# Rezoning Transportation Analysis

Petition Number: #2022-111

## Revision Log:

| Date     | Description        |
|----------|--------------------|
| 12-22-22 | Second Review (DR) |

REZONING PLAN

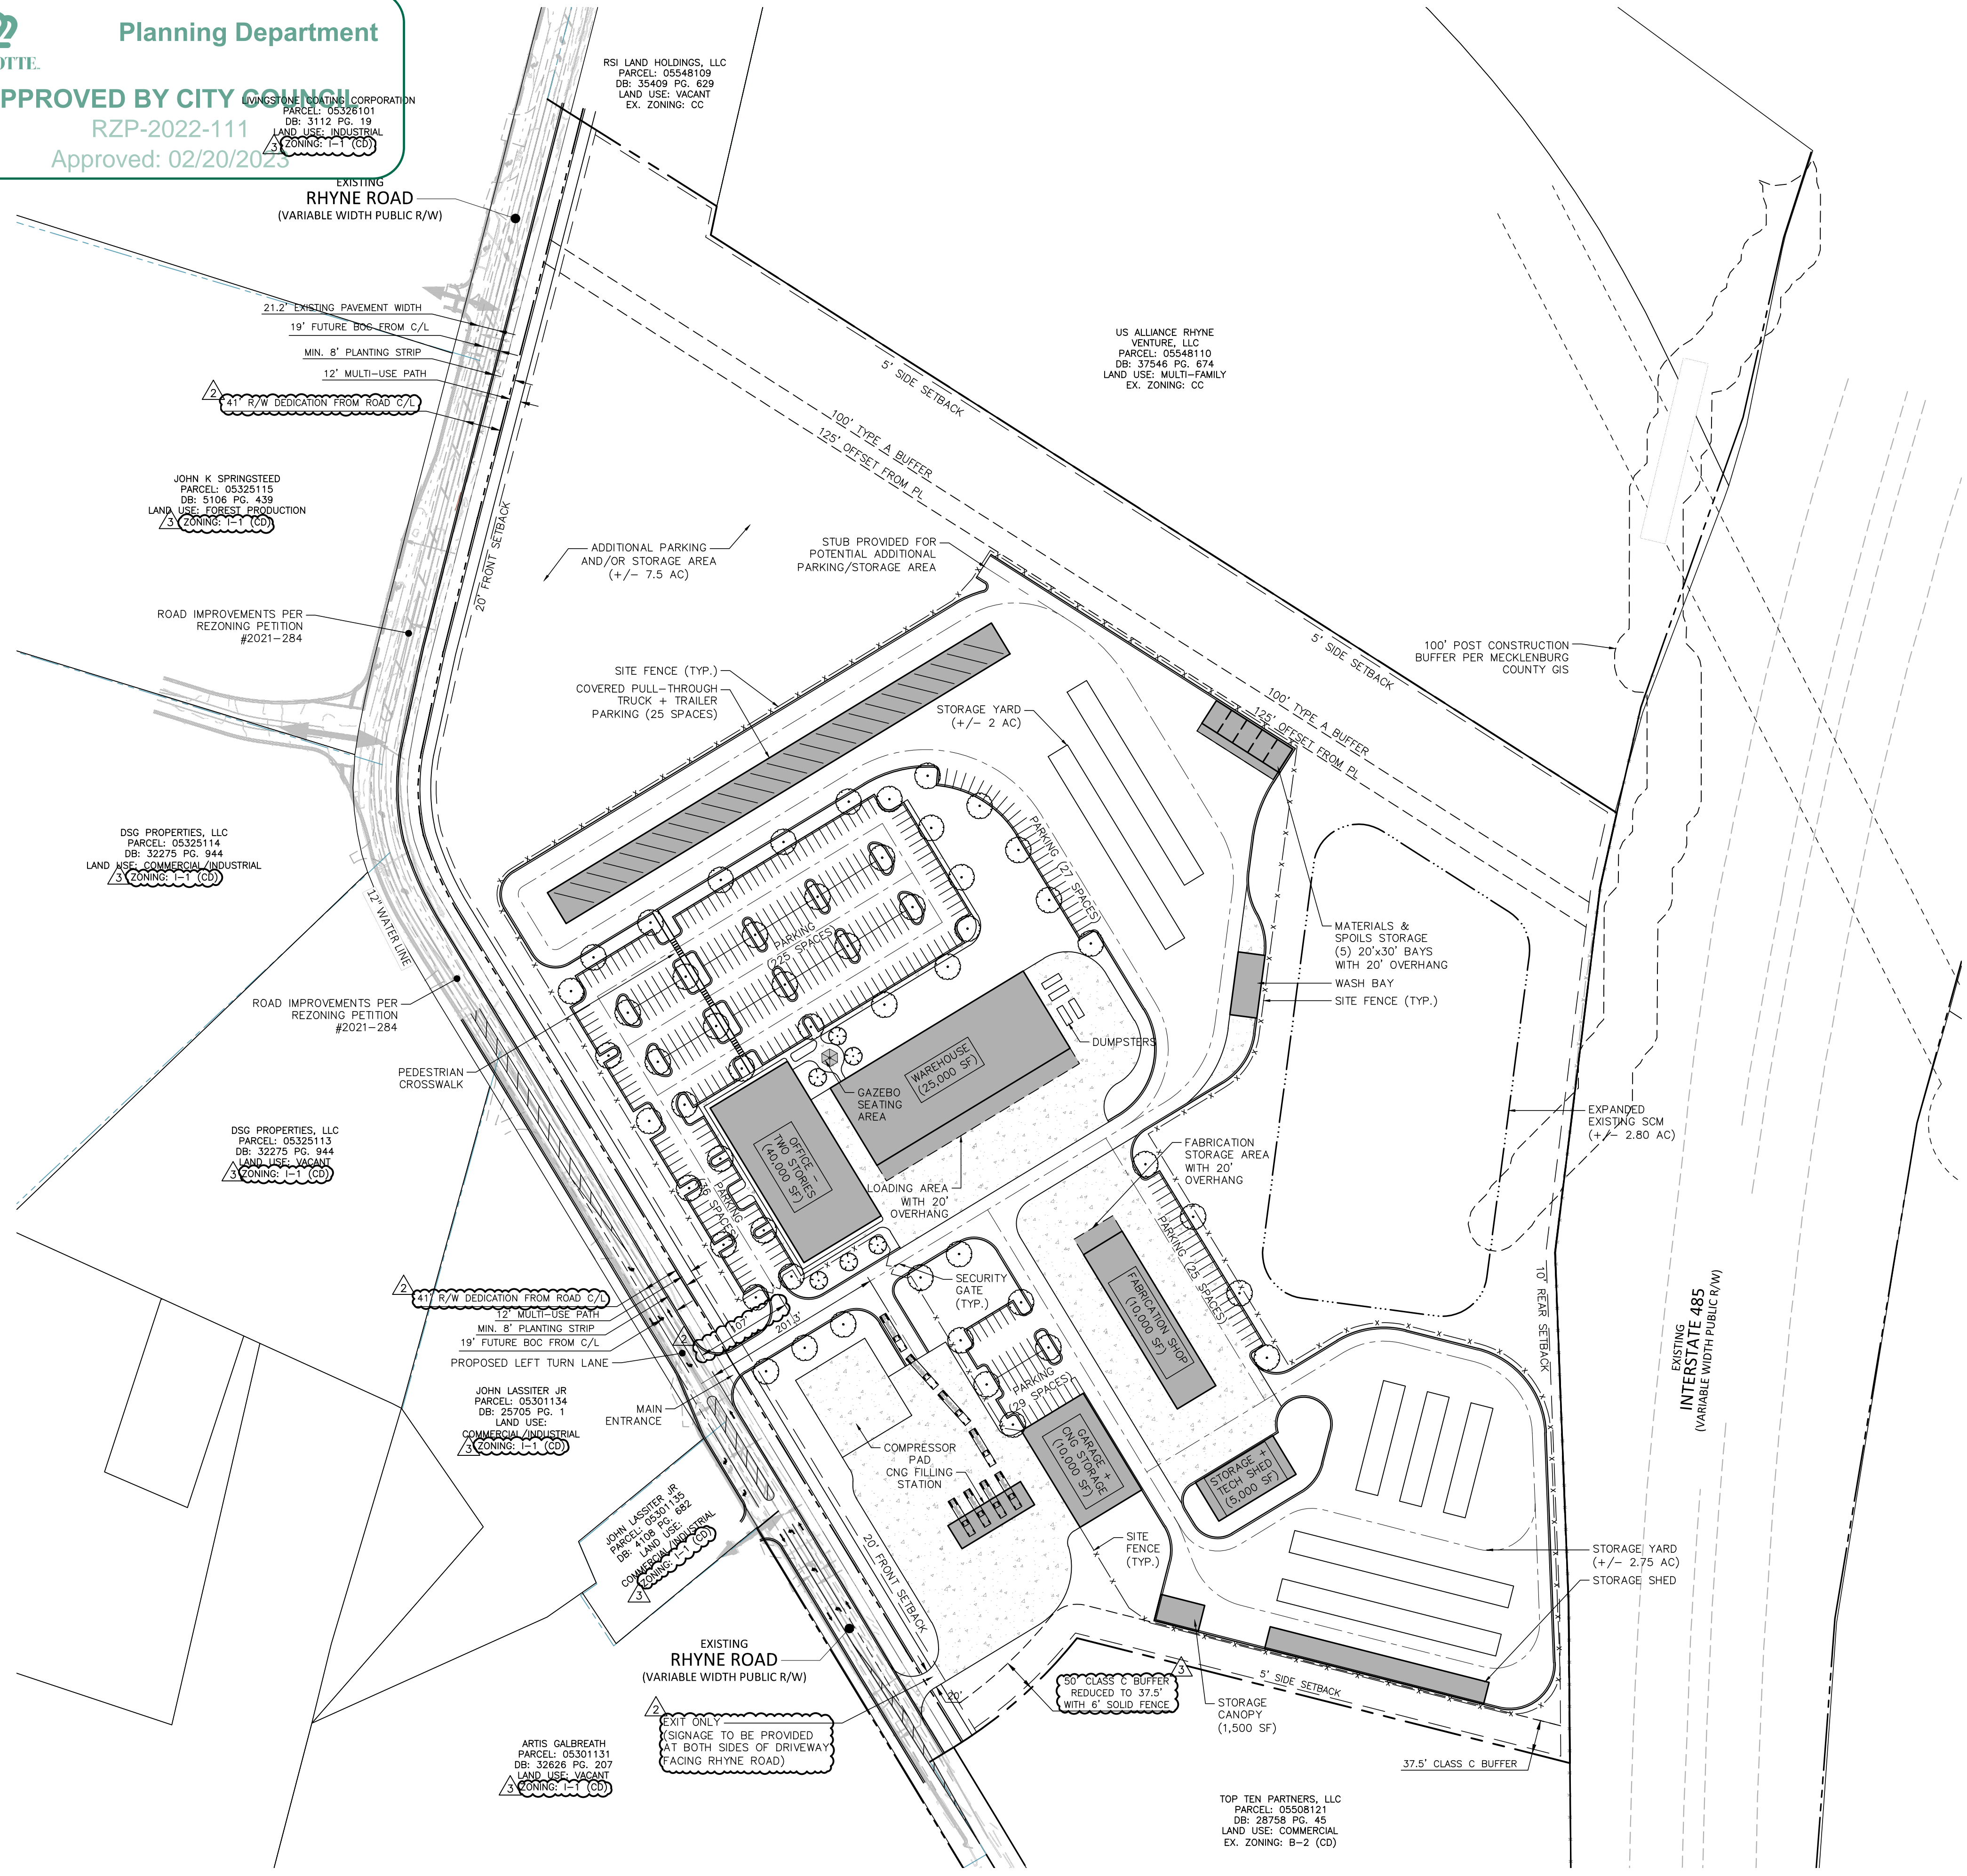
3. Revise site plan and conditional note(s) to commit to dedicate 41-feet of right-of-way, along the site's frontage of Rhyne Road, from the road centerline. The site plan shall label and dimension the right-of-way from the road centerline.

**Clarifying comment from 12/22/2022:** Add conditional note to dedicate 41-feet of right-of-way along site's frontage of Rhyne Road from the road centerline.

- Per coordination with NCDOT, revise site plan and conditional note(s) to consolidate the proposed access points for the site. All access points on Rhyne Road will need a minimum of 100-foot of protected storage and a turnaround should be provided for gated driveways. In addition, add conditional note that all driveways must meet intersection sight distance requirements to receive a driveway permit.

**Clarifying comments from 12/22/2022:** Per NCDOT, add conditional note that all driveways must meet intersection sight distance requirements to receive a driveway permit. Per NCDOT as well, add conditional note that 100-foot protected stem will be required for all driveways.

- New Comment from 12/22/2022:** Remove unnecessary callouts for security gate and secondary entrance as shown in image below.

Remove callouts for security gate and secondary entrance. Don't look like they are needed here anymore.

8. **New Comment from 12/22/2022:** The exit only driveway needs to be reconfigured to prevent potential ingress traffic or removed altogether.
